# City of Albuquerque

**RE: JAGUAR PRECISION MACHINE, INC. (J14-D130). ENGINEER'S CERTIFICATION FOR CERTIFICATE OF OCCUPANCY APPROVAL. ENGINEER'S STAMP DATED MAY 3, 2000.**

DRAINAGE AND GRADING PLAN
BUILDING ADDITION
JAGUAR PRECISION MACHINE, INC.

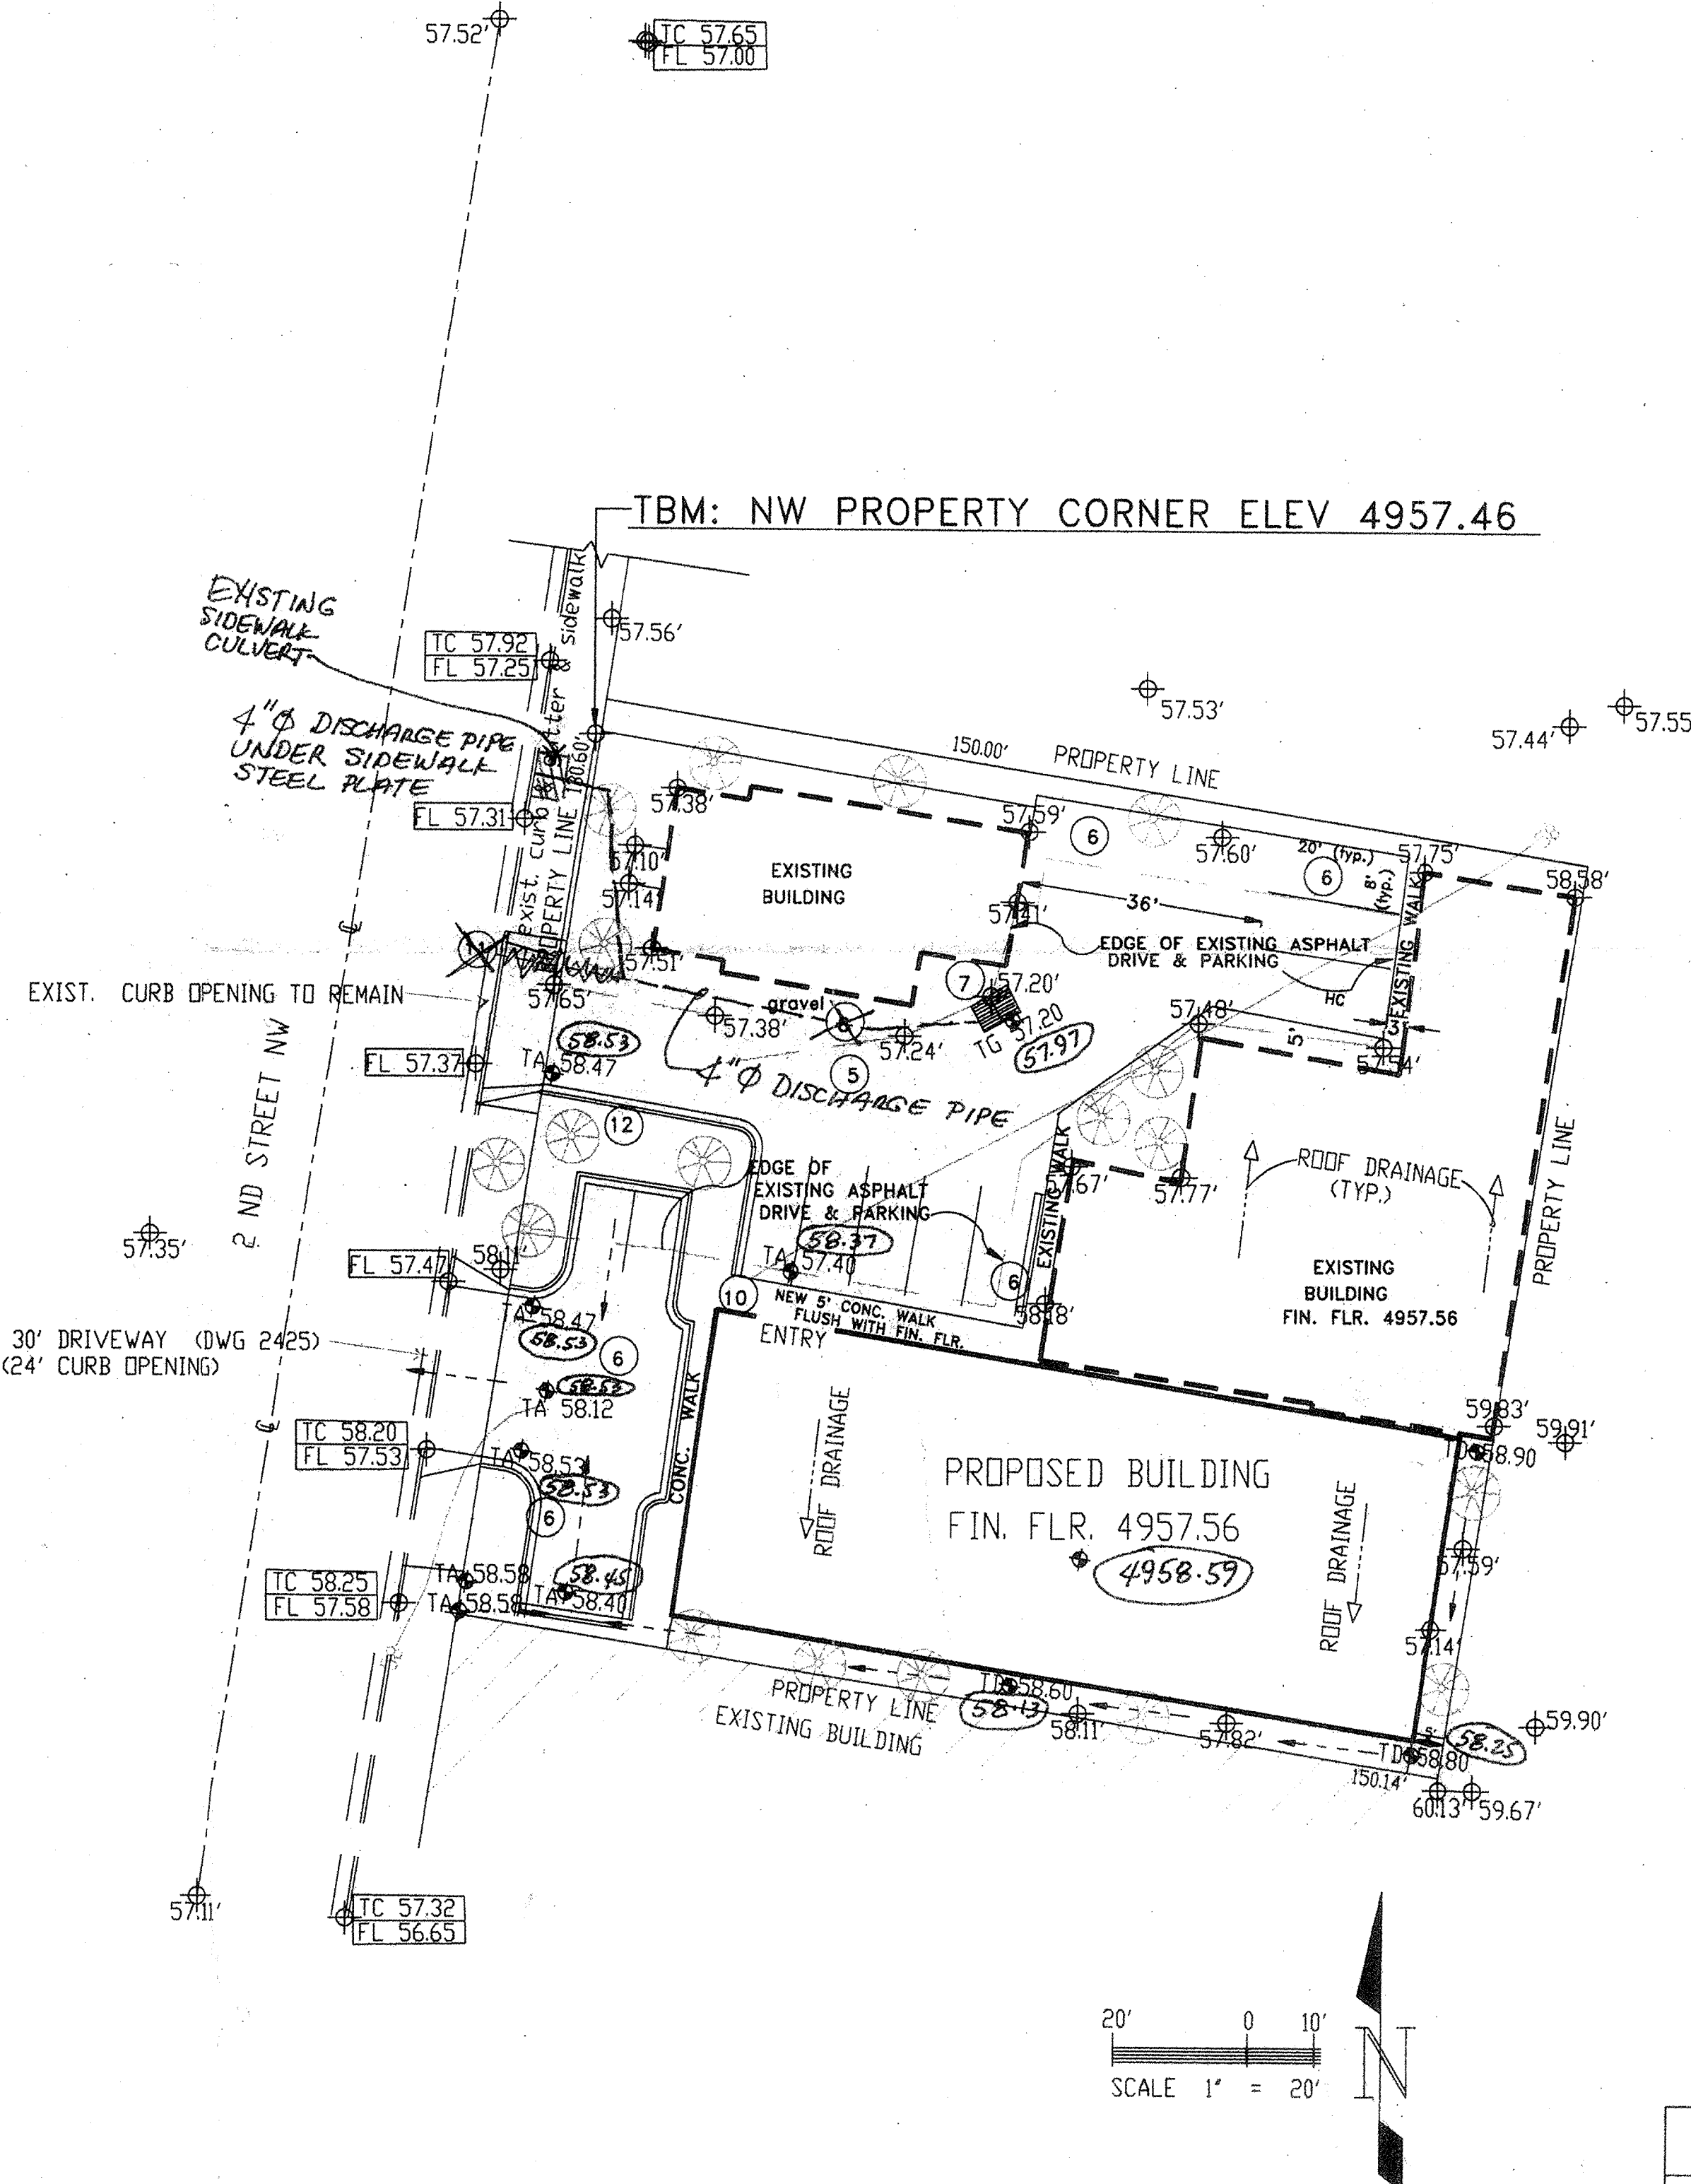
Storm Drain Maintenance field inspected the SO#19 insallation on May 15, 2000. It is not as depicted on the Grading and Drainage Plan which you certified. See enclosed copy of photos.

While the changes would not necessarily prevent the approval of the C.O., it is critical for the Engineer's Certification to be thorough. Please resubmit said Certification showing actual conditions.
